**File:** 071122 - 1280 Trim Road

## **RESPONSE TO R1 FEEDBACK FOR ZBL FILE NO D02-02-24-0024 - 1280 TRIM ROAD**

The following outlines the detailed responses to the First Round Technical Agency Feedback Form dated September 11 2024.

02 BUILDING 2 and 3 ELEVATIONS

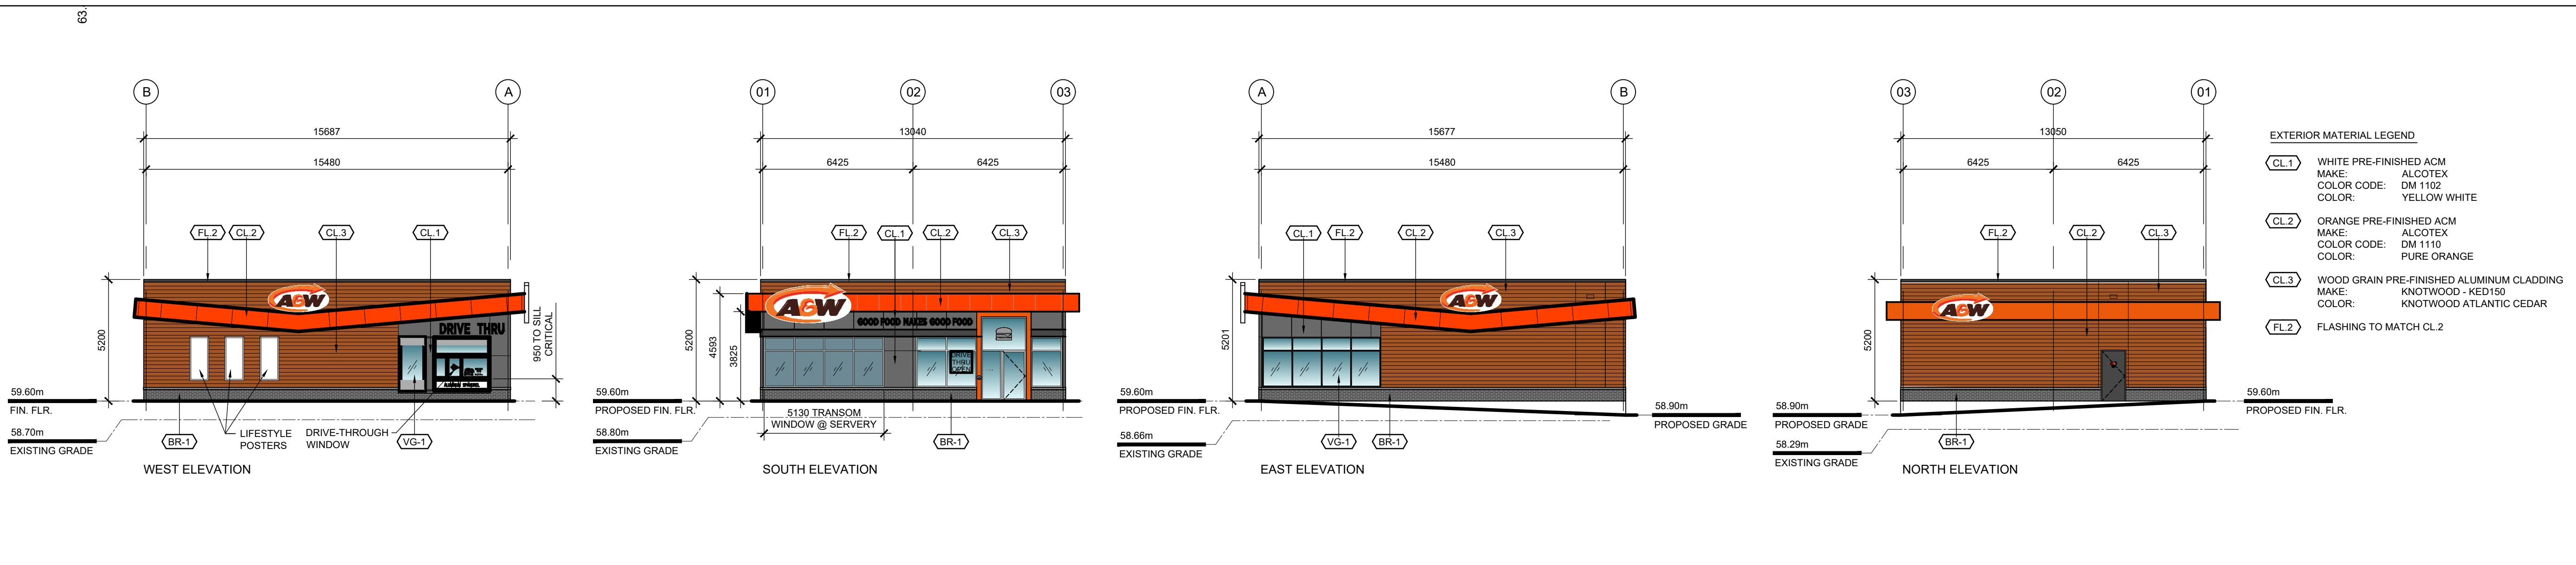
9. Please confirm there is exterior lighting on the elevations. There is no label/legend indicating so.

SP-A01

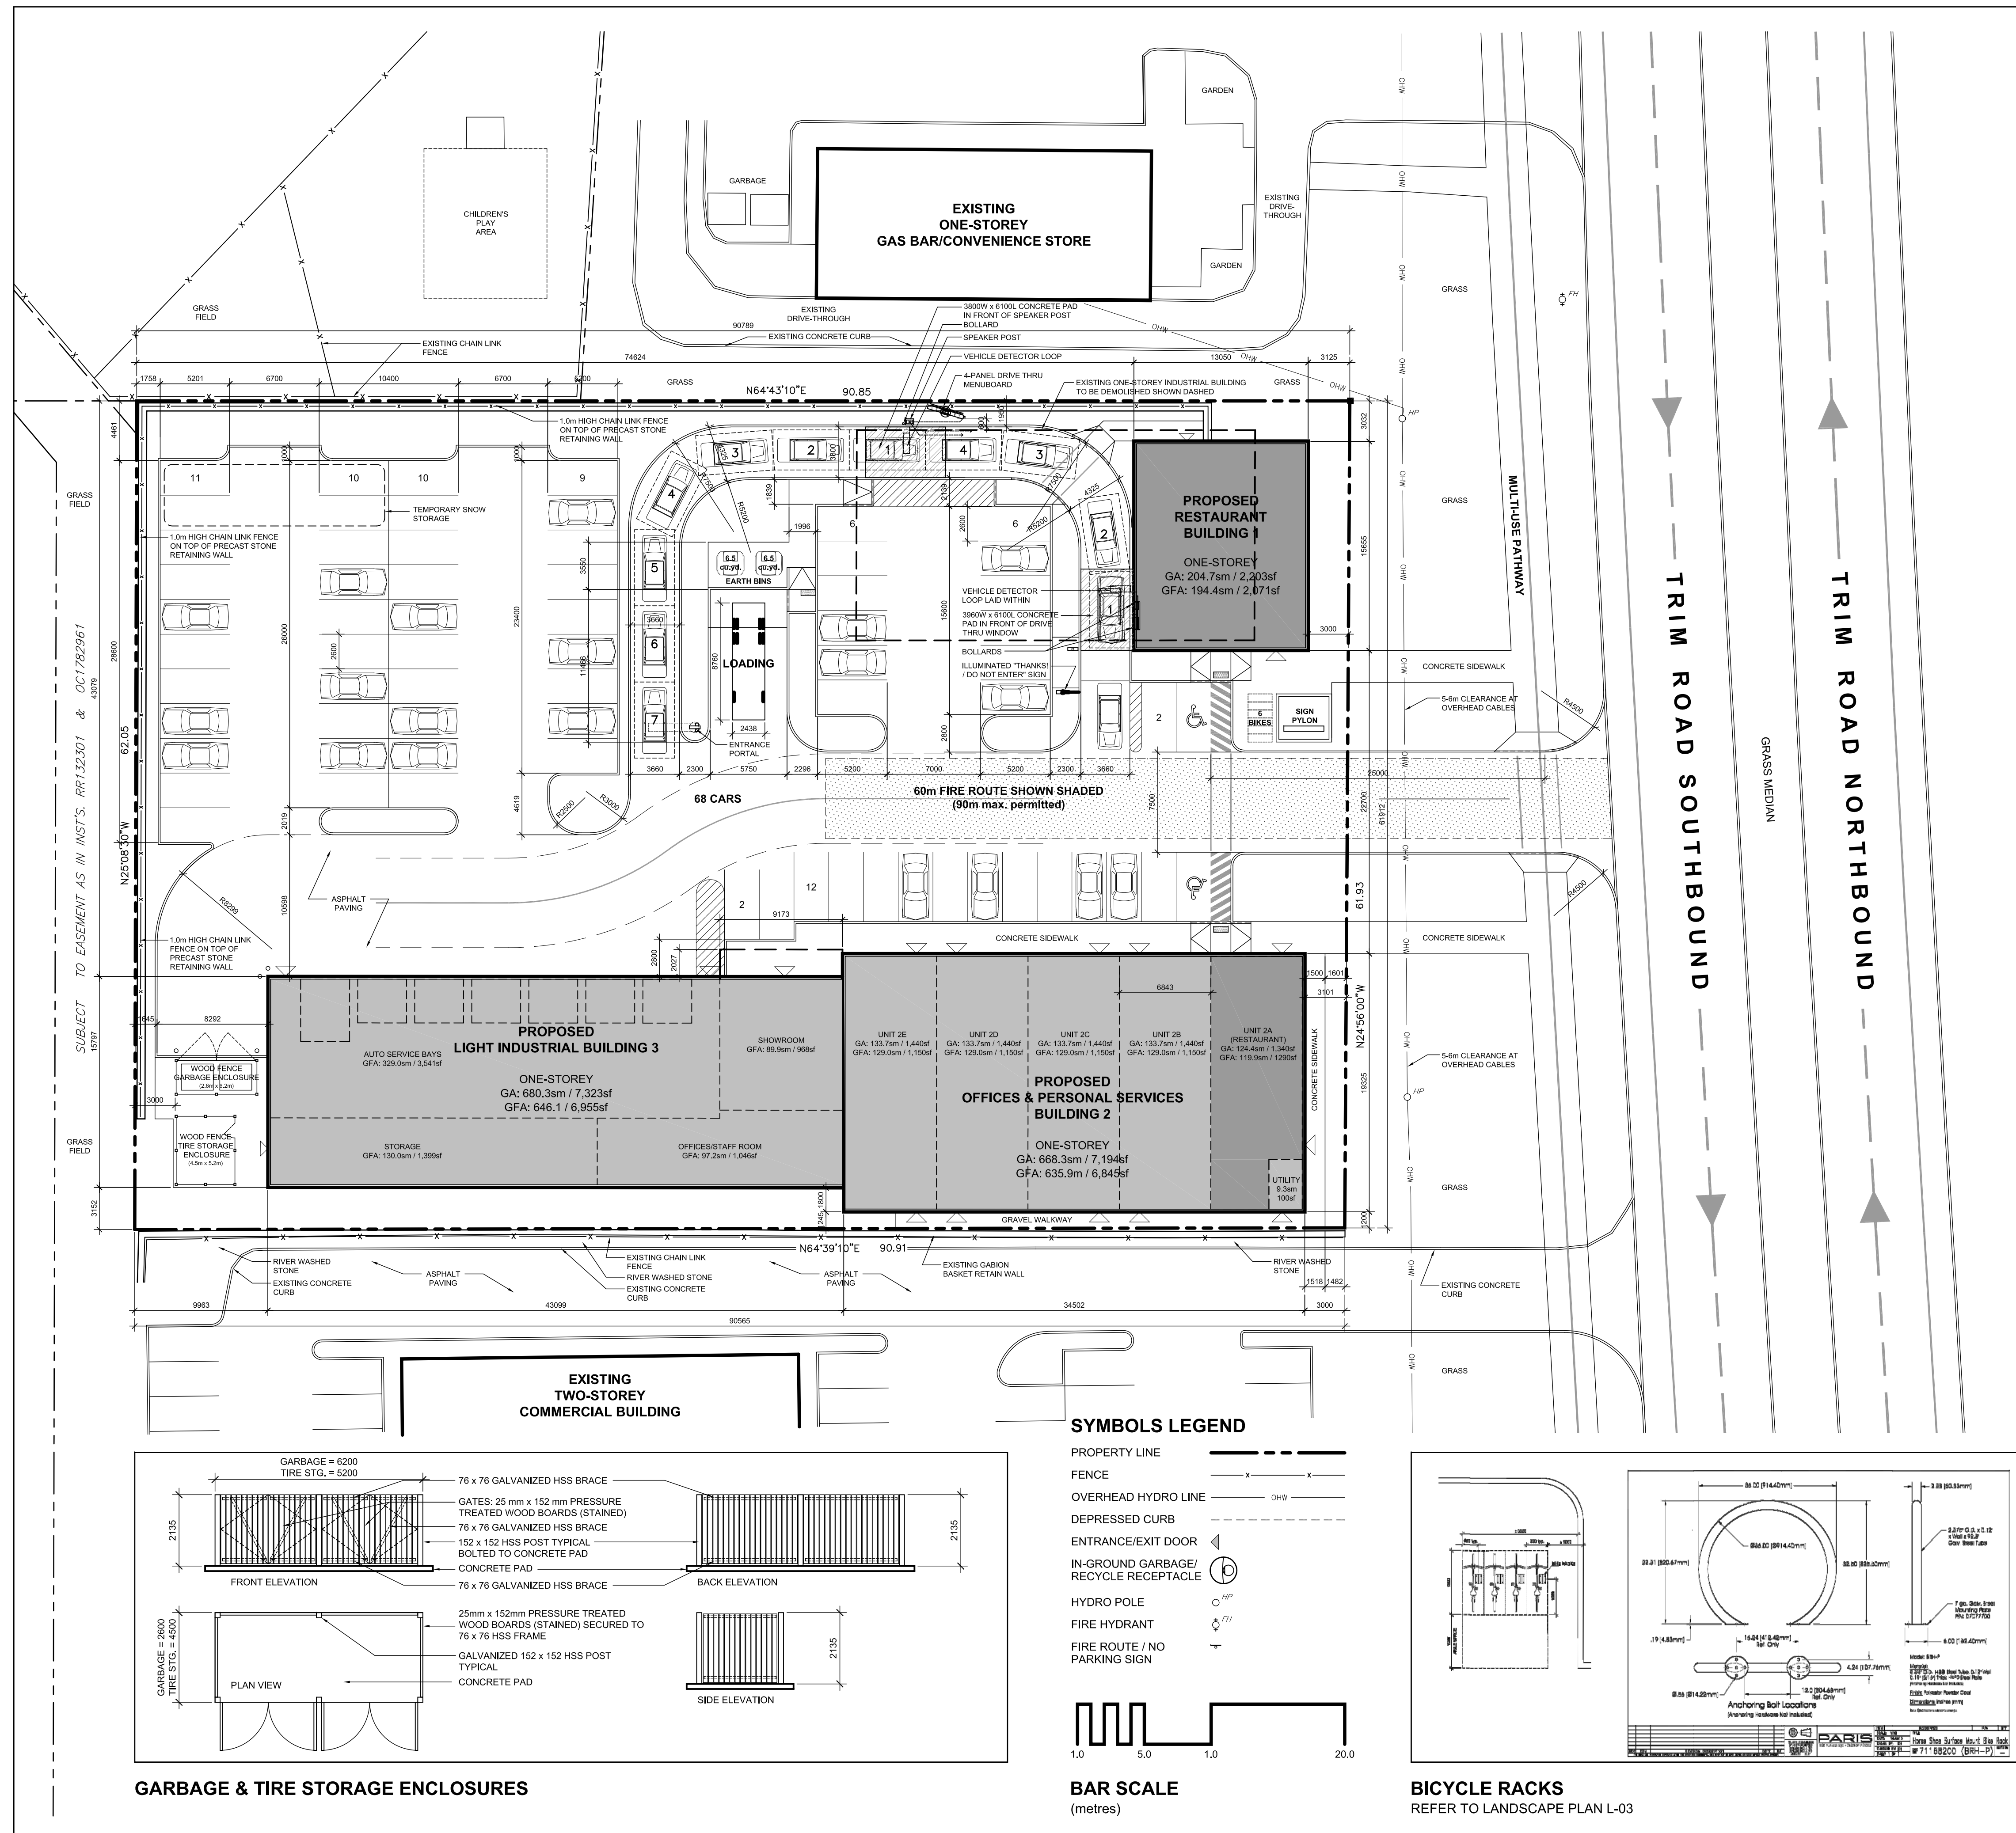
3. Per the Official plan, policy 4.6.2 (4), buildings should be oriented towards the scenic route. Per the Secondary Plan along corridors, active frontages are required to enhance the public realm and animate the street (section 4.5). Ideally, there would be entrances for the restaurants that face the street. In your planning rationale you state that “Building 2 provides a door facing the public street” (page 29 and 30). Per the elevations there does not appear to be a door the public can use, just a side door. Have you looked at having active entrances for the restaurants facing the public street? Can you provide an active entrance for at least one of the buildings, building 2? In the design brief it also says you’re providing a door(entrance) facing the public street.

16. The following comments are applicable to the Site Plan: Show/note material on Multi-Use Pathway, the concrete sidewalk appears to simply tie into the MUP, however the difference in materials should be clear.

17. As previously noted, there must not be a curb across the MUP, depressed or otherwise. The MUP must be continuous asphalt across the access, see schematic below.

**] Q9 \_ A pedestrian access and door has been added to the Trim Road frontage for Building 2, Unit 2 A.**

] **Q9 \_The site plan has been updated to specify the material for the MUP (asphalt) and the sidewalk (concrete)**

] **Q9 \_The site plan has been updated to specify that there is continuous asphalt across the entrance to the MUP.**

scale NTS	drawn by M. Malkov	designed by R. Ruhlhand
date Sep. 2023	checked by R. Ruhlhand	plot date
project number 23-1713	drawing number L - 01 Landscape Plan

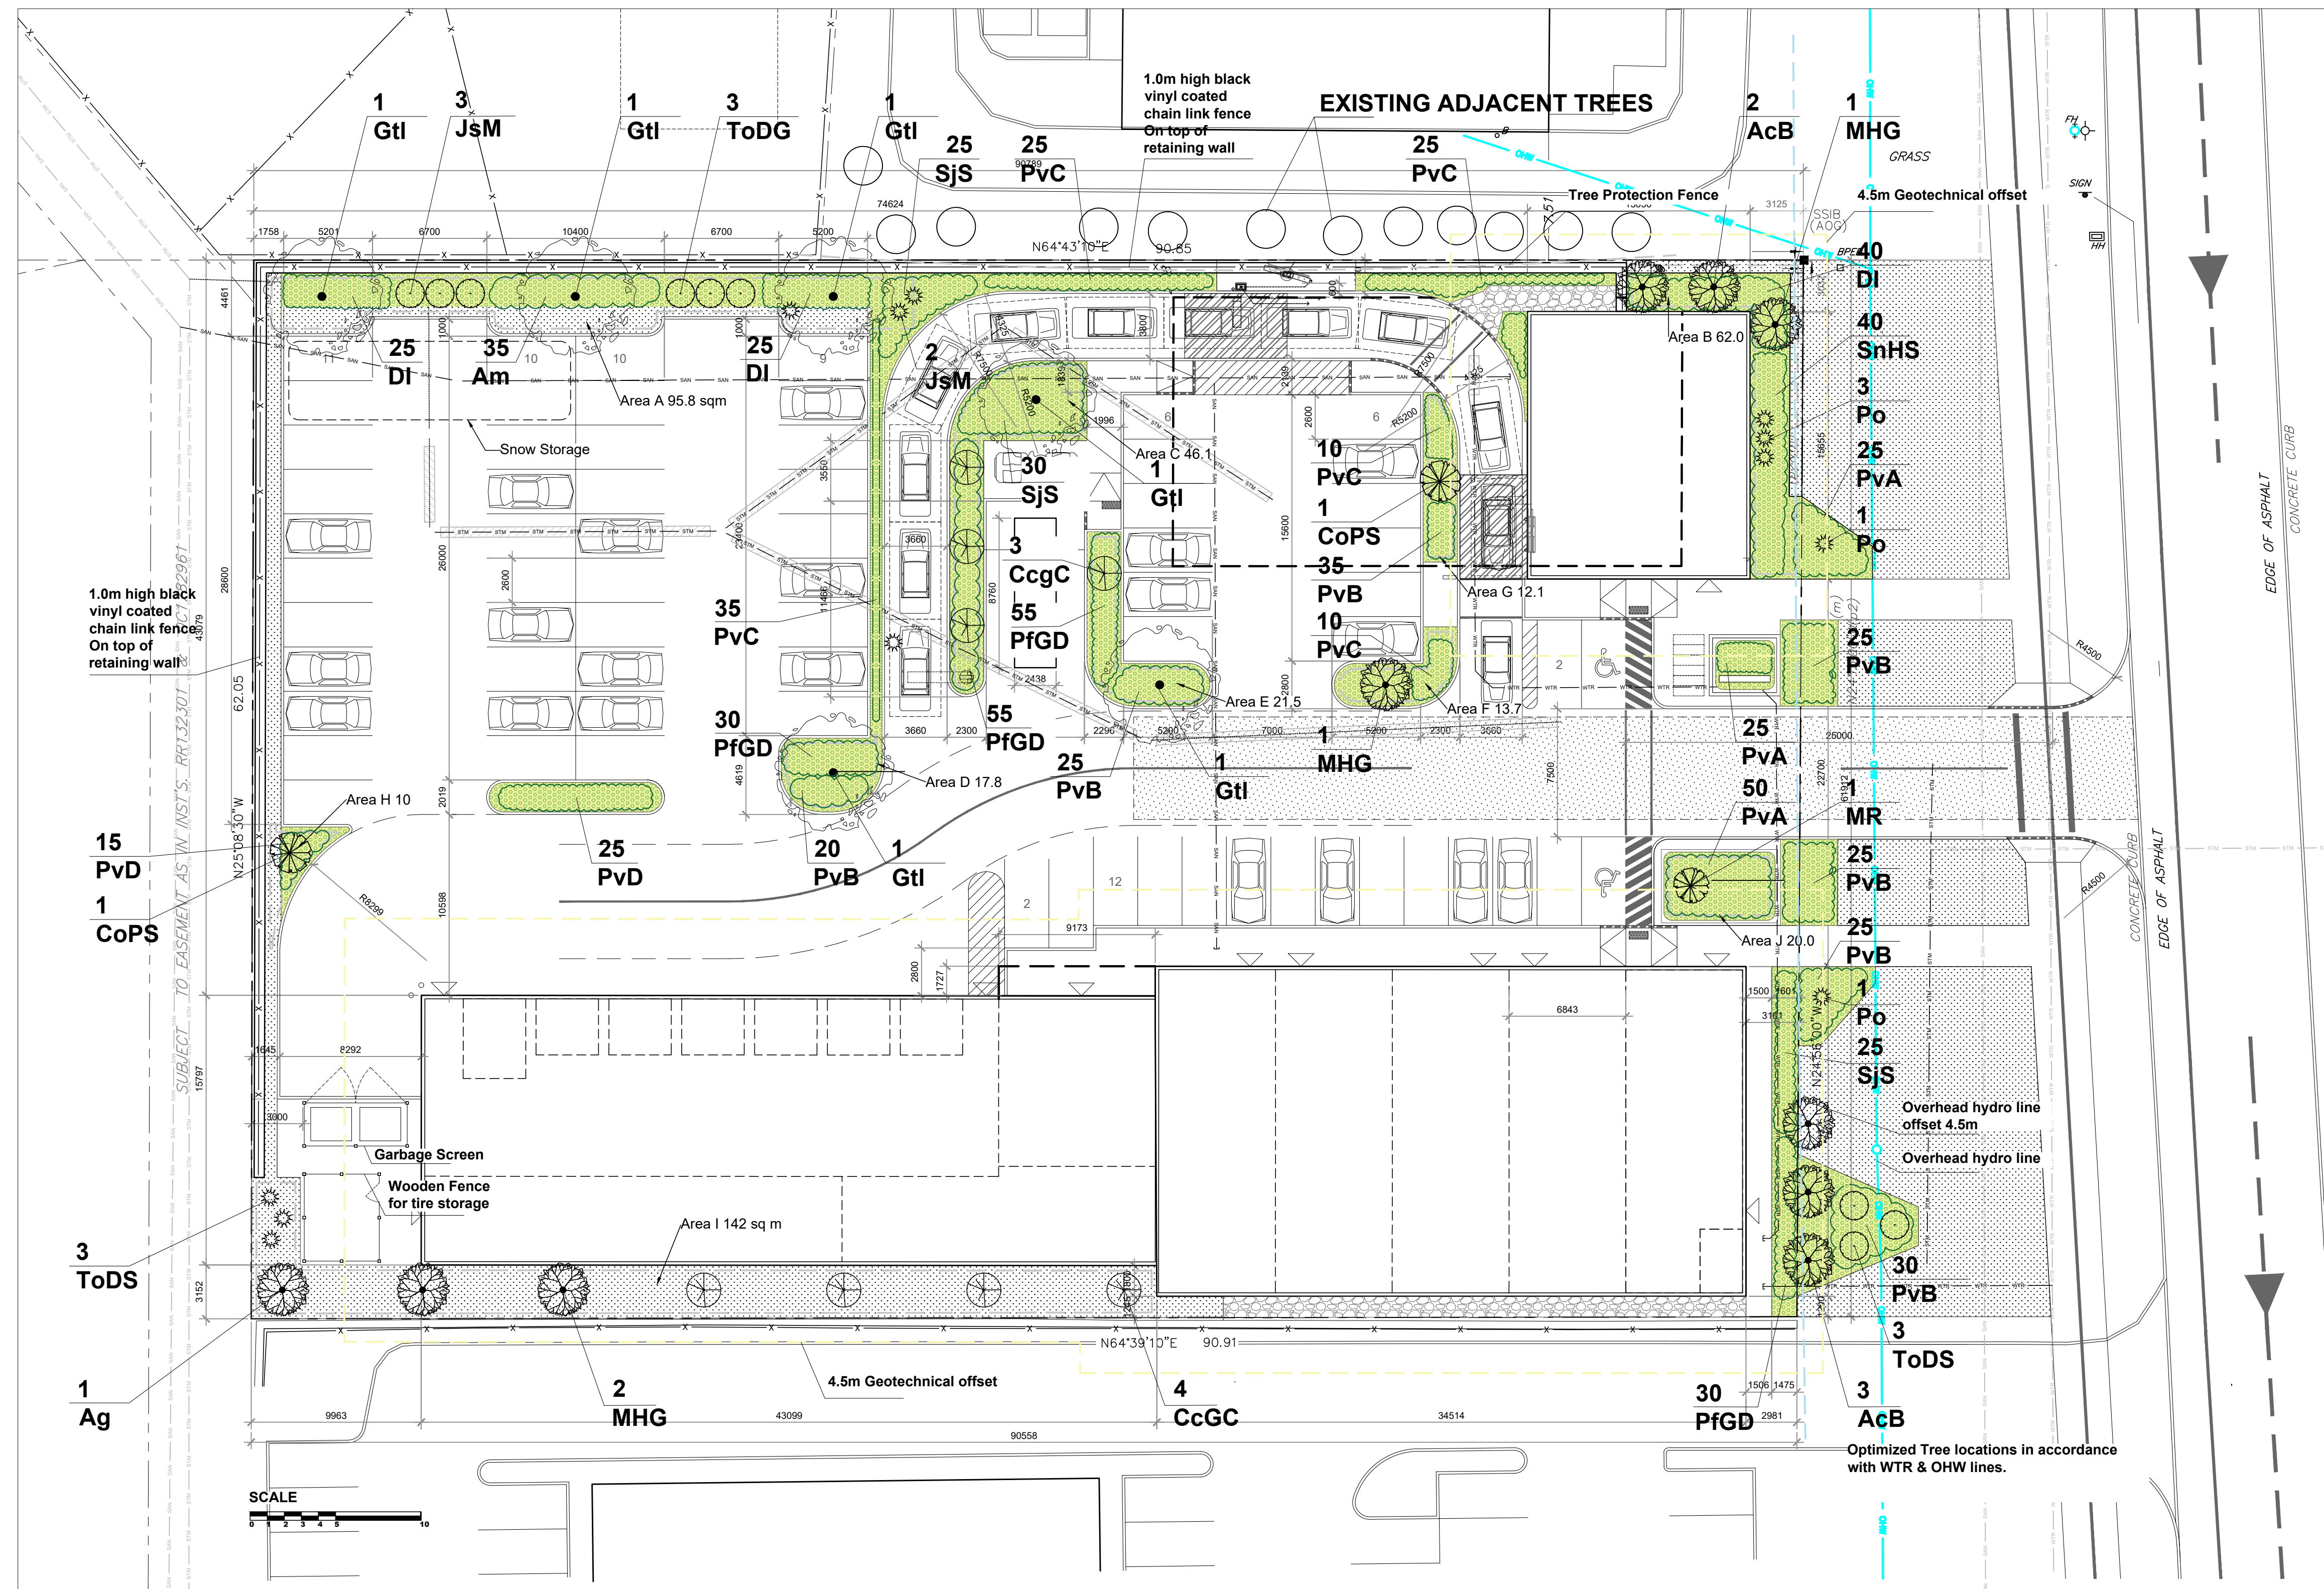
5. There is inconsistency between the Site Plan and Landscape Plan for the 'walkway' on the north end of the drive-through building. It's labelled as a gravel pathway on the LP but as a concrete walk on the SP, please clarify.

6. The tree protection fence for adjacent property trees is not identified (label is there, but no leader or fence line).

] **Q9 \_ This has been revised and plans have been coordinated.**

] **Q9 \_ Fence is indicated as a zig-zag line on revised Landscape Plan.**
